Response to TIS Comments – Honor Charter School – El Paso County, CO

Kellar Engineering (KE) comment responses in **blue** font.

SIGNAGE AND STRIPING PLAN

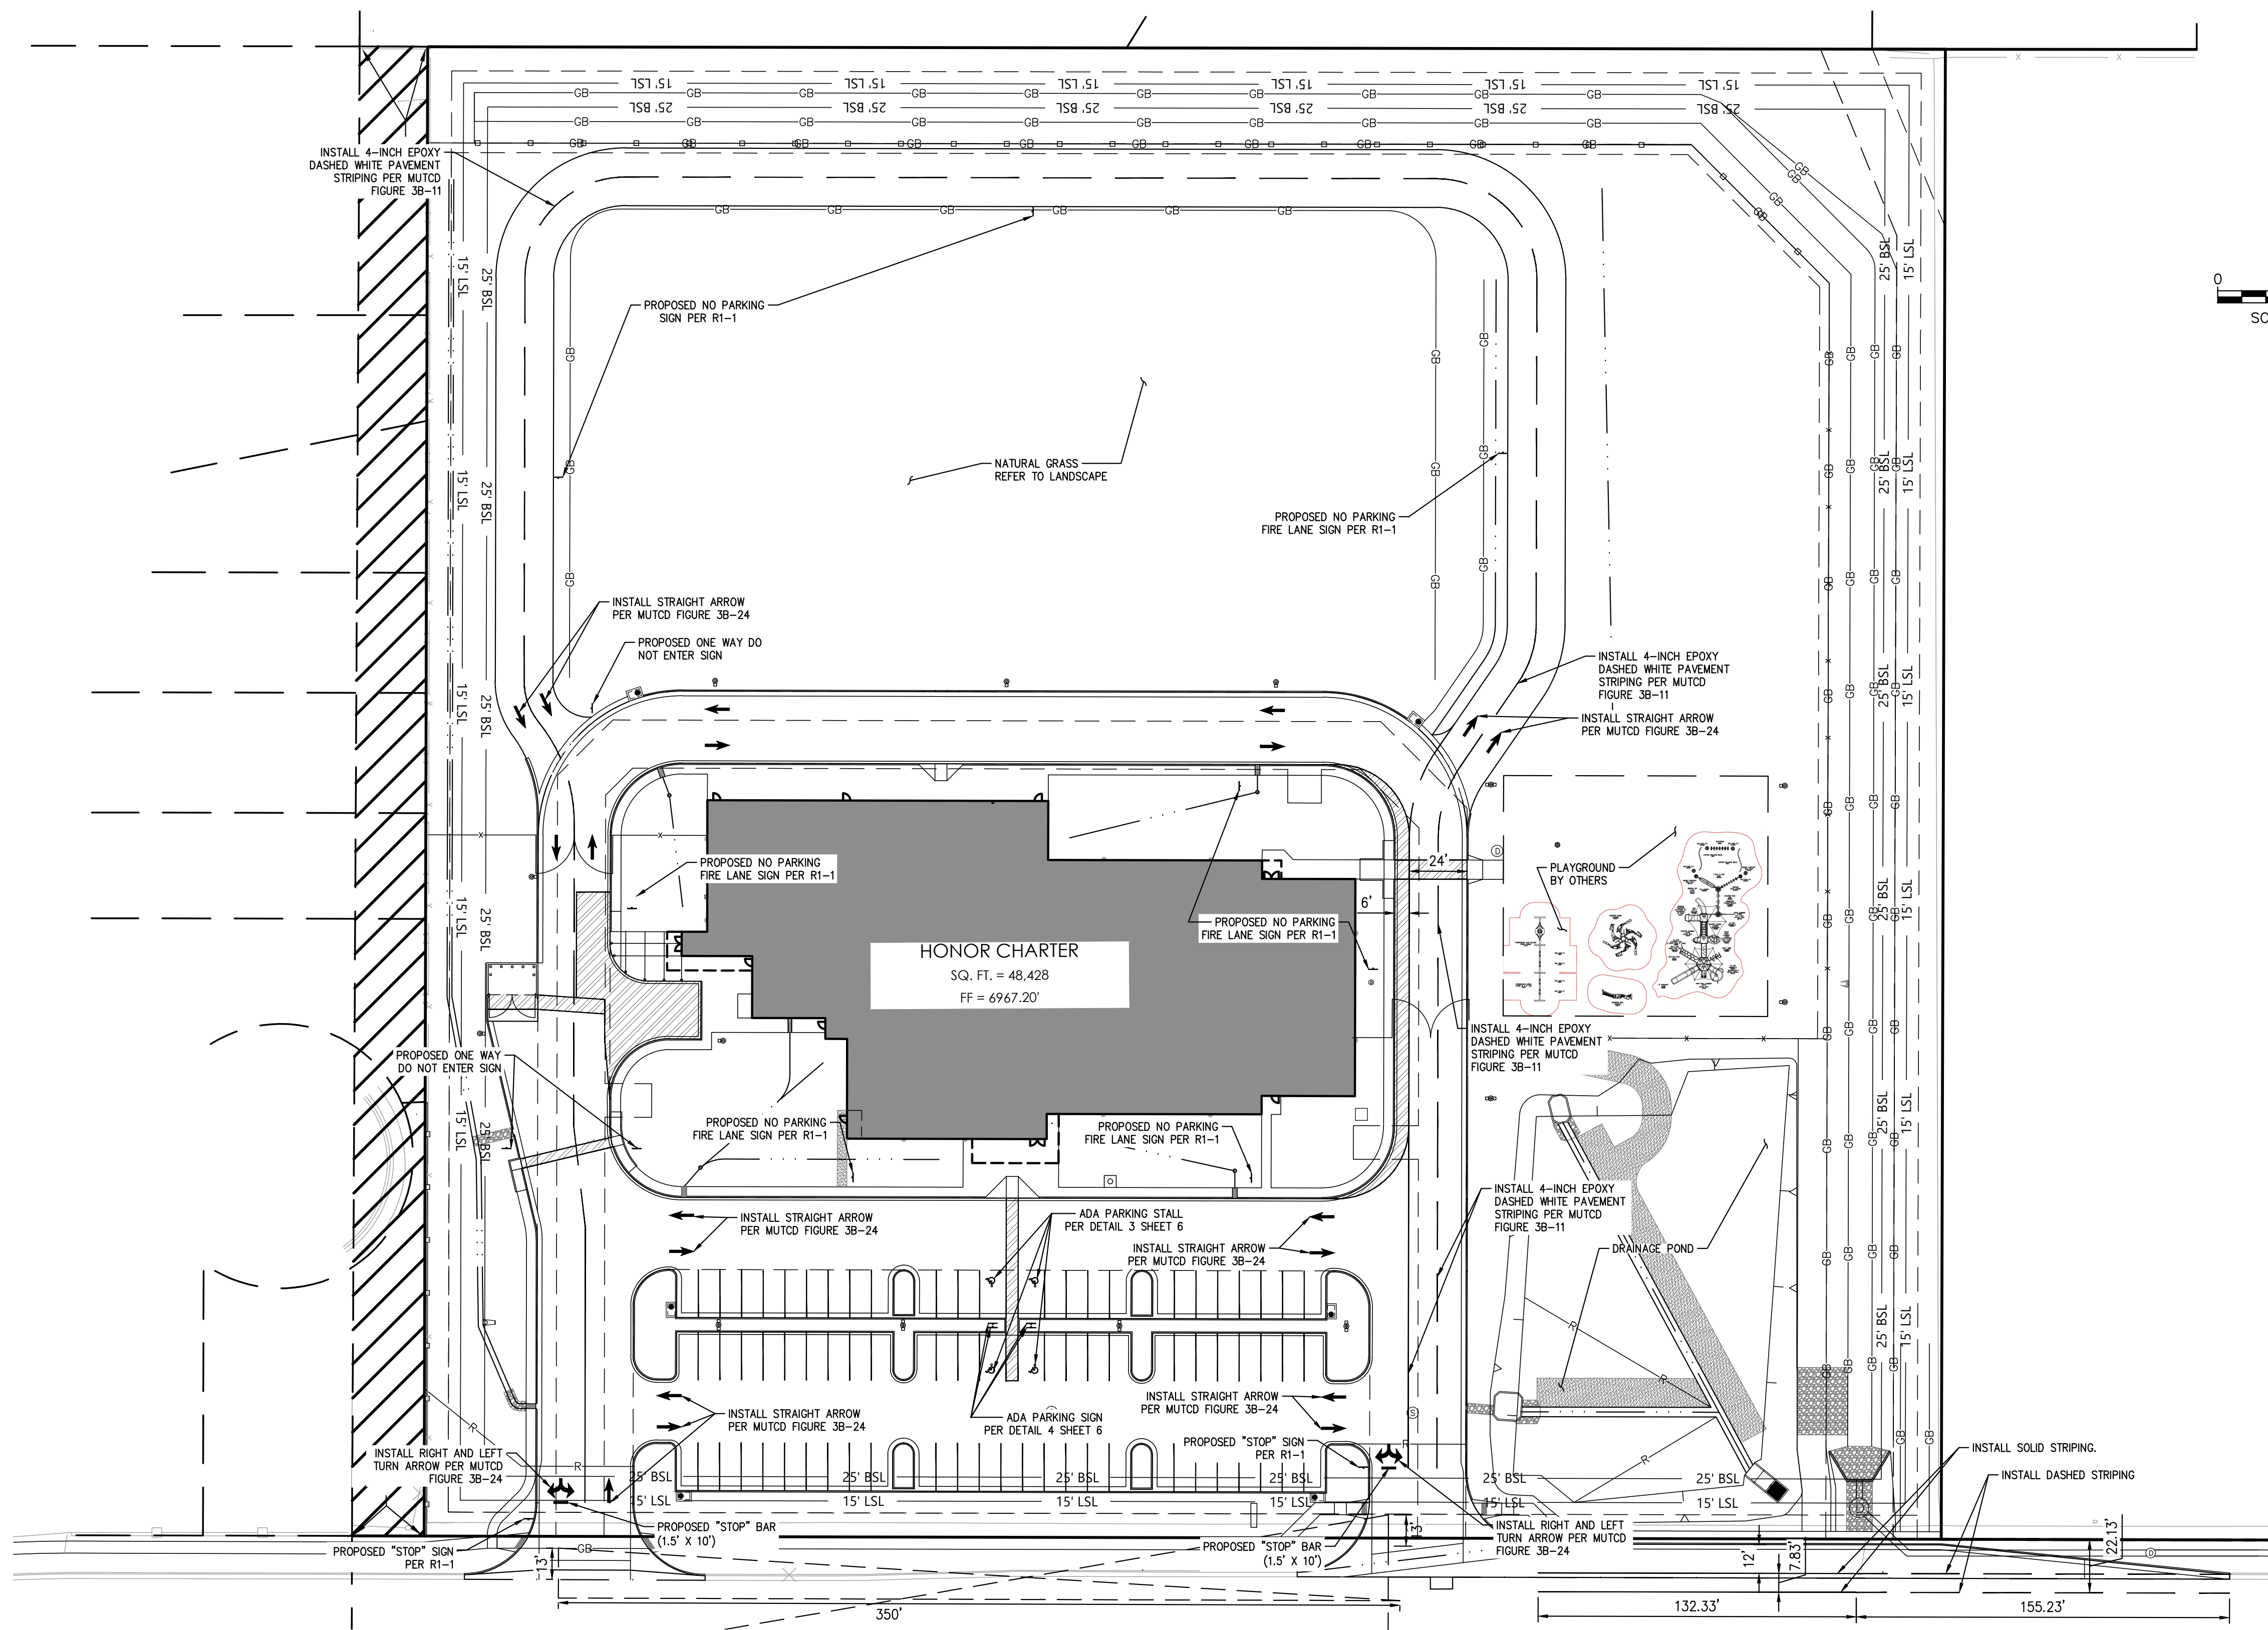
11. Identify safe routes to school and ensure proper signings and markings are installed prior to the first day of school. Any crosswalks required across Bent Grass Meadows? New state laws identify the School Zone as being 1,000-ft minimum from all school boundaries. Ensure proper signing and pavement markings per MUTCD is installed with a signing and striping plan.

Response: Per email correspondence with Scott Barnhart, Traffic Operations Manager, a separate signing and striping plan sheet showing the placement of school advance warning signs, school speed limit signs, and "end school zone" signs along Bent Grass Meadows Drive per the MUTCD requirements has been provided. KE has coordinated with the school and project team and they have indicated that they do not anticipate needing a crosswalk.

Figure 3: Recent Peak Hour Traffic

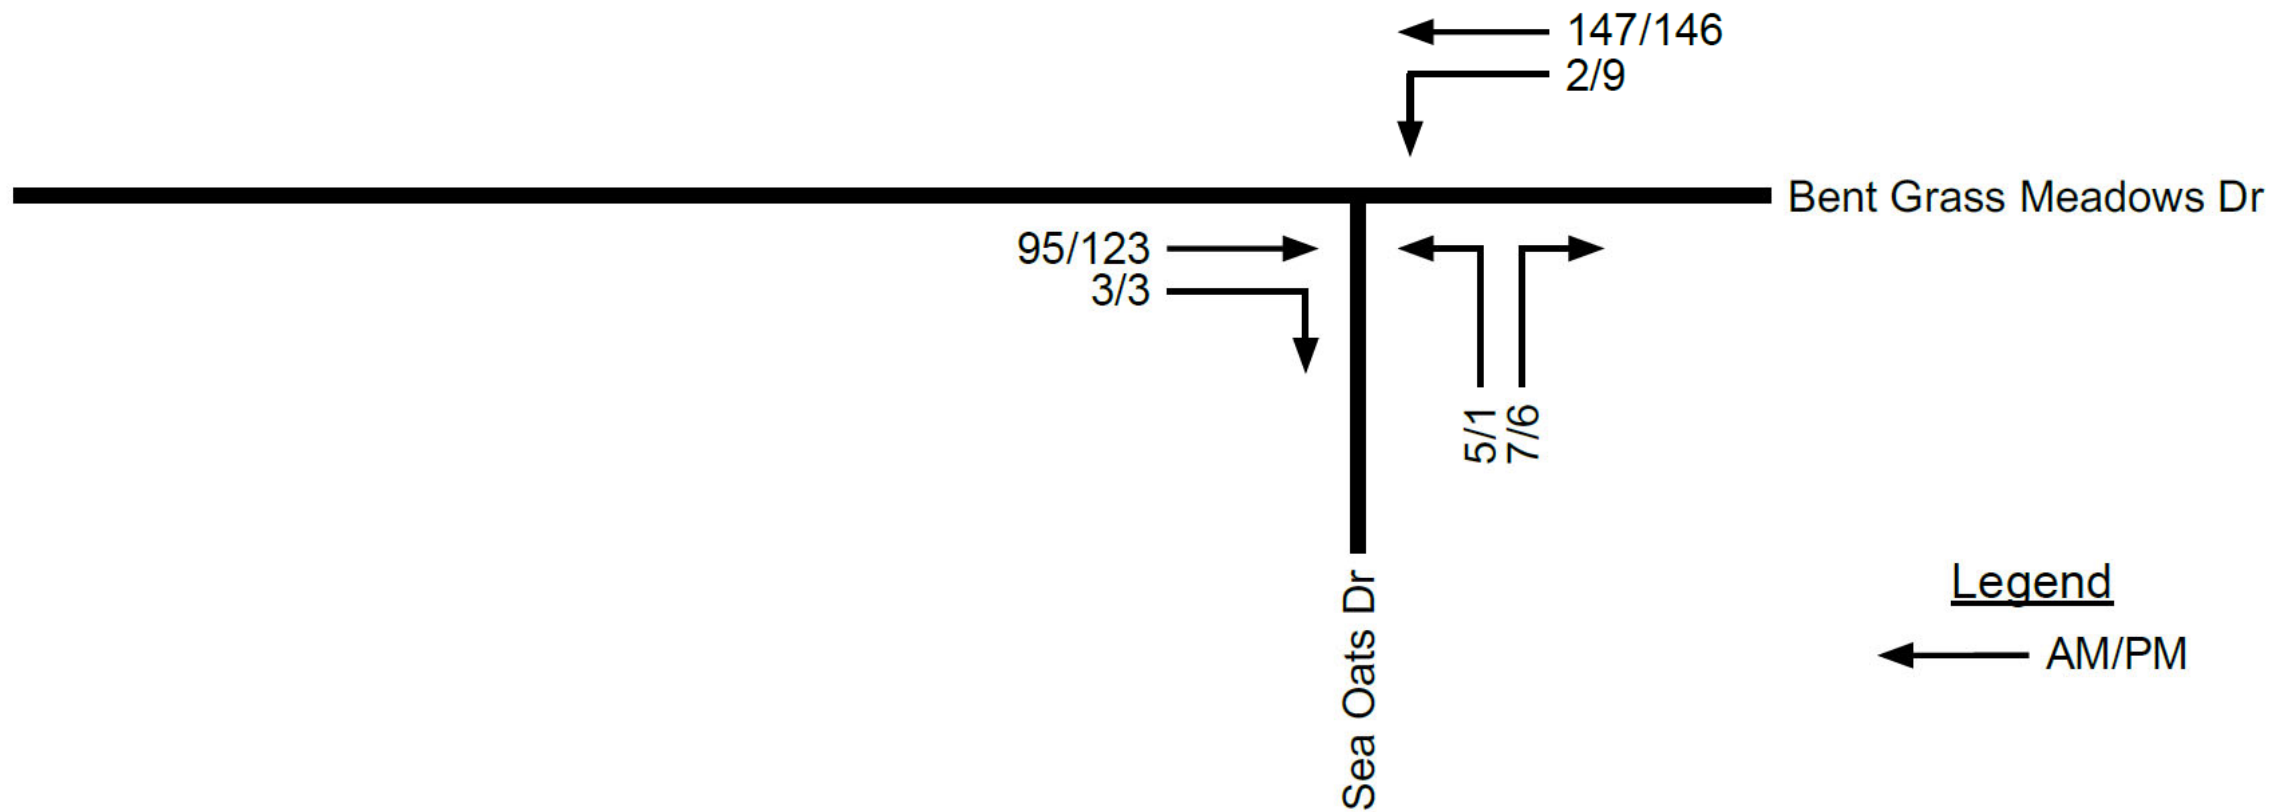
9. In addition to analyzing the intersection of Sea Oats Dr and Bent Grass Meadows Dr, please analyze the following intersections: Bent Grass Meadows Dr and Meridian, Bent Grass Meadows Dr and E Woodmen Rd Frontage.

Response: The TIS has been updated to include these intersections.

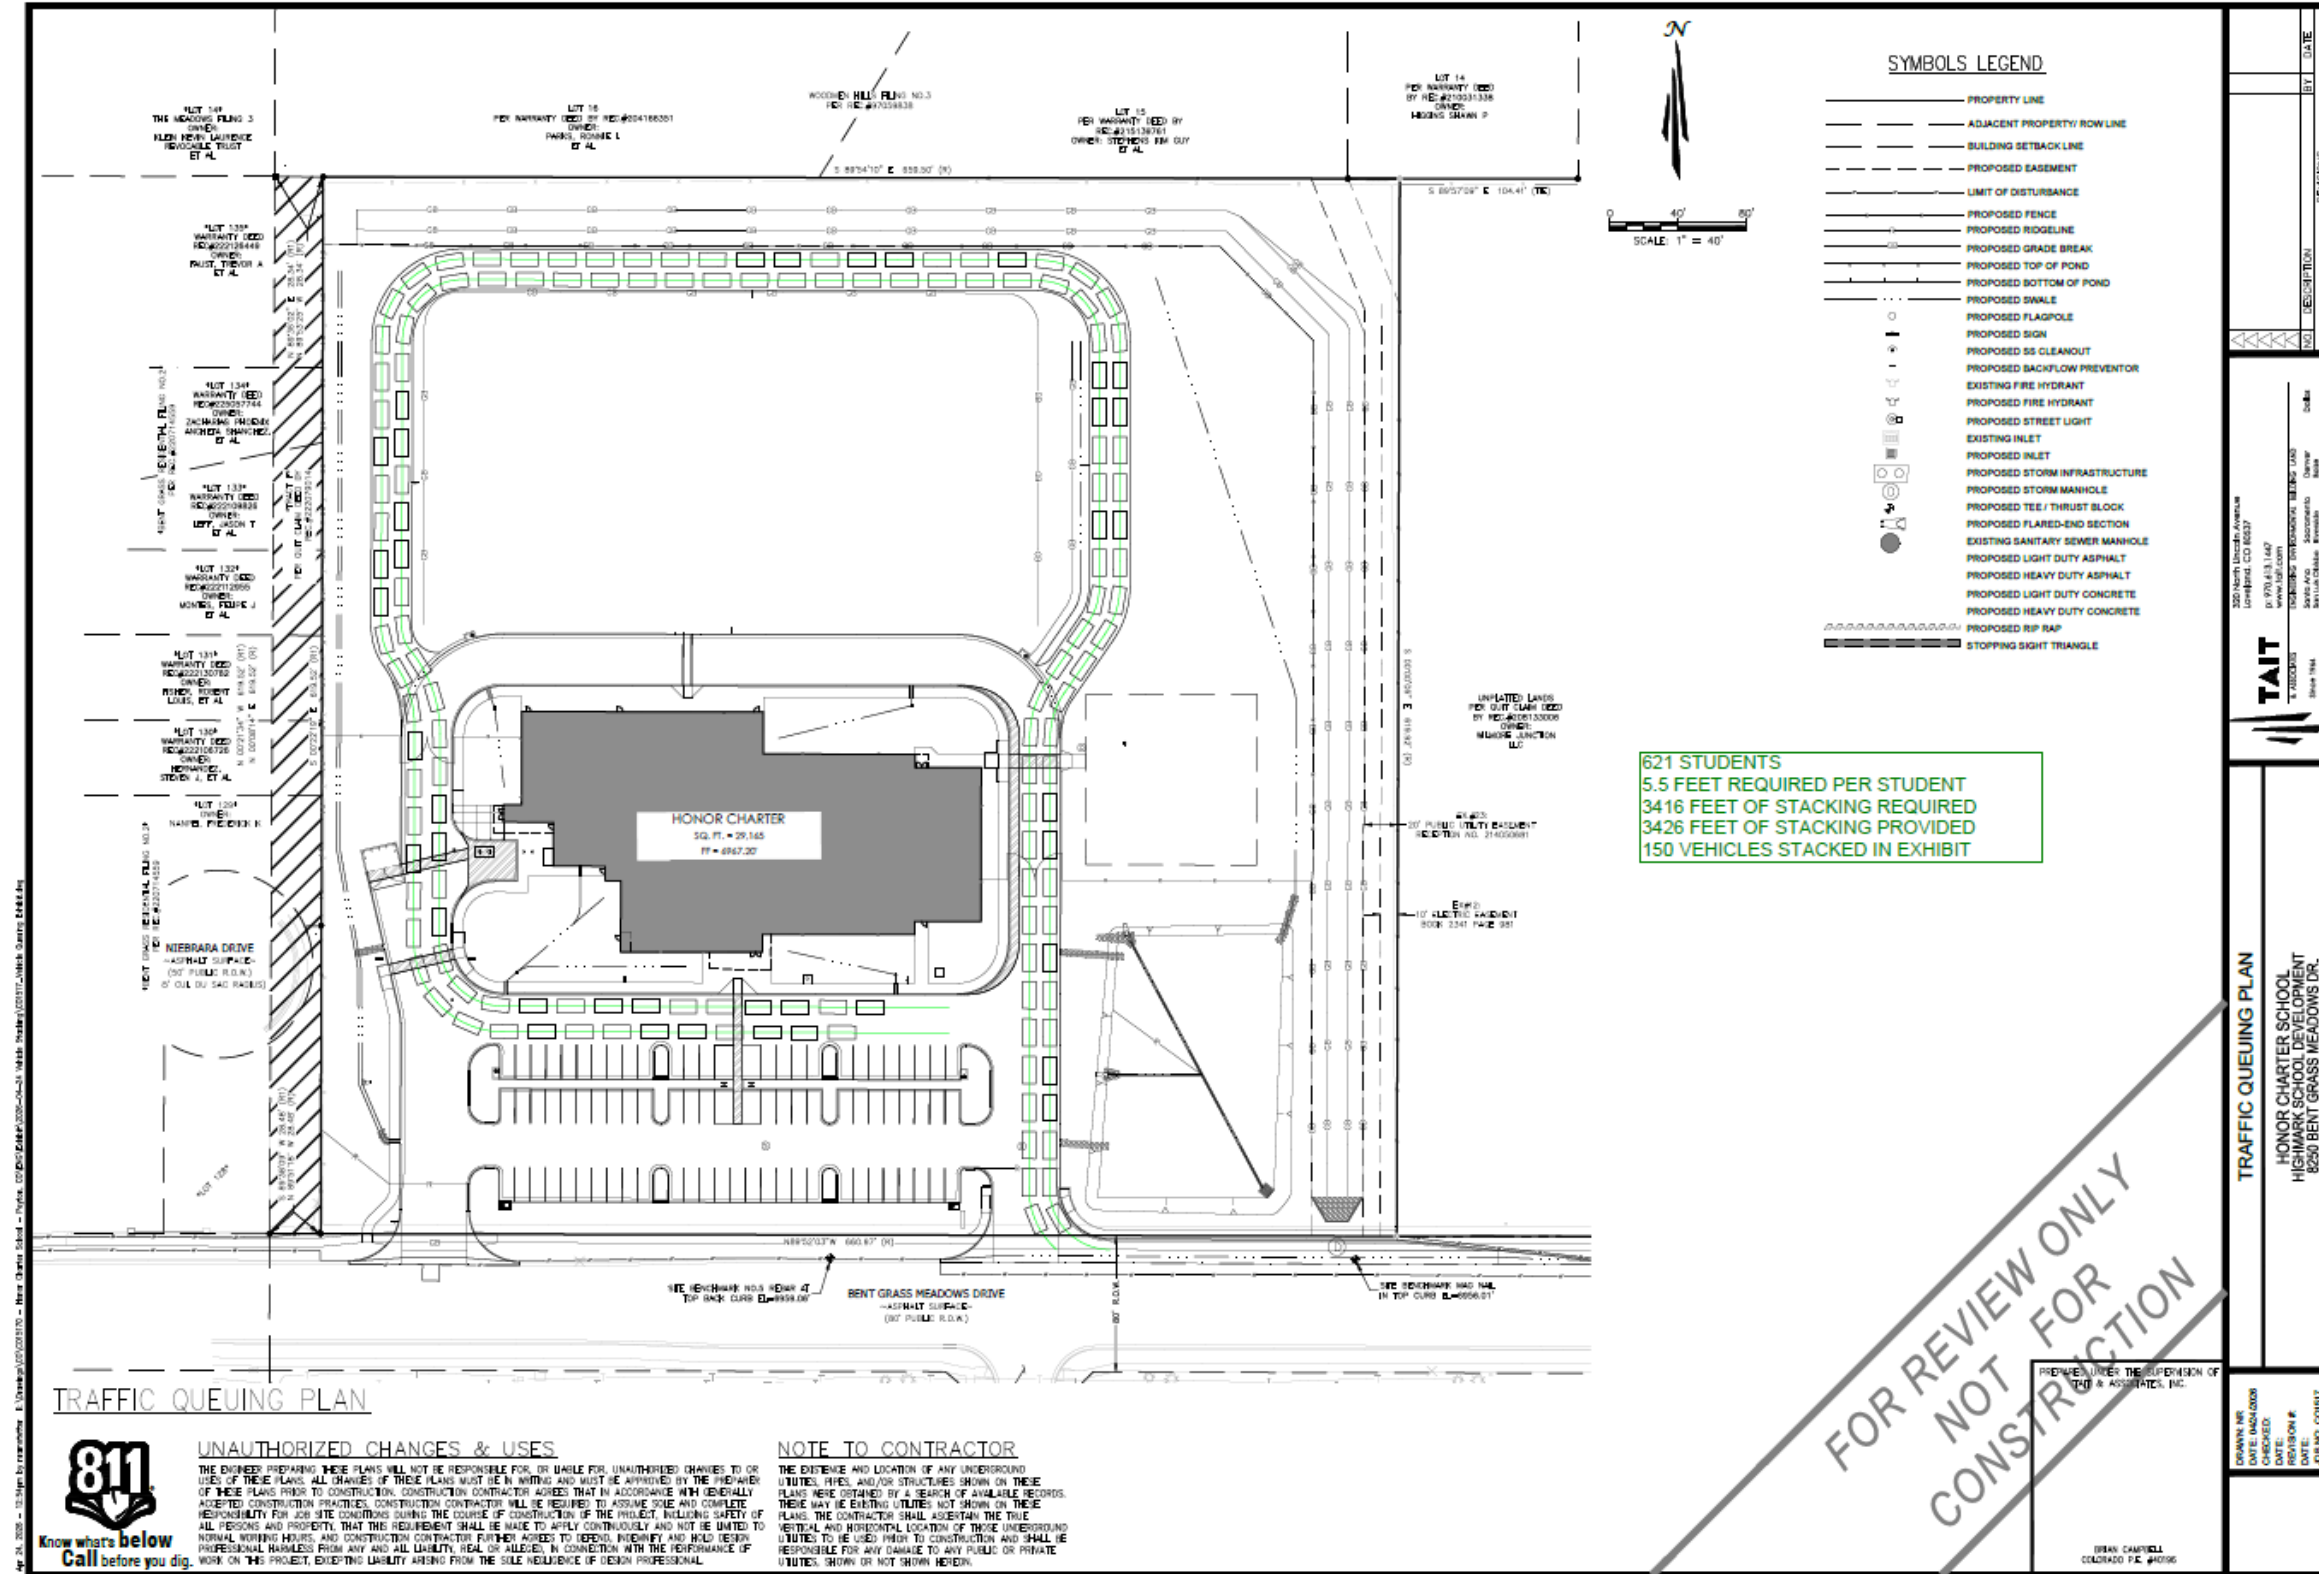
7. Please define NCDOT.
Response: The TIS has been updated to include more text defining the NCDOT calculator for school stacking length calculations.
8. Ensure school staff is aware of the vehicle stacking length intent. This is not always communicated and traffic queuing is backed onto the public street. Create a pick-up/drop-off operations manual for school staff.

Response: Per email correspondence with Scott Barnhart, Traffic Operations Manager, a parking/queuing operations guide has been prepared for the school to use to ensure that traffic will not back onto the public street.
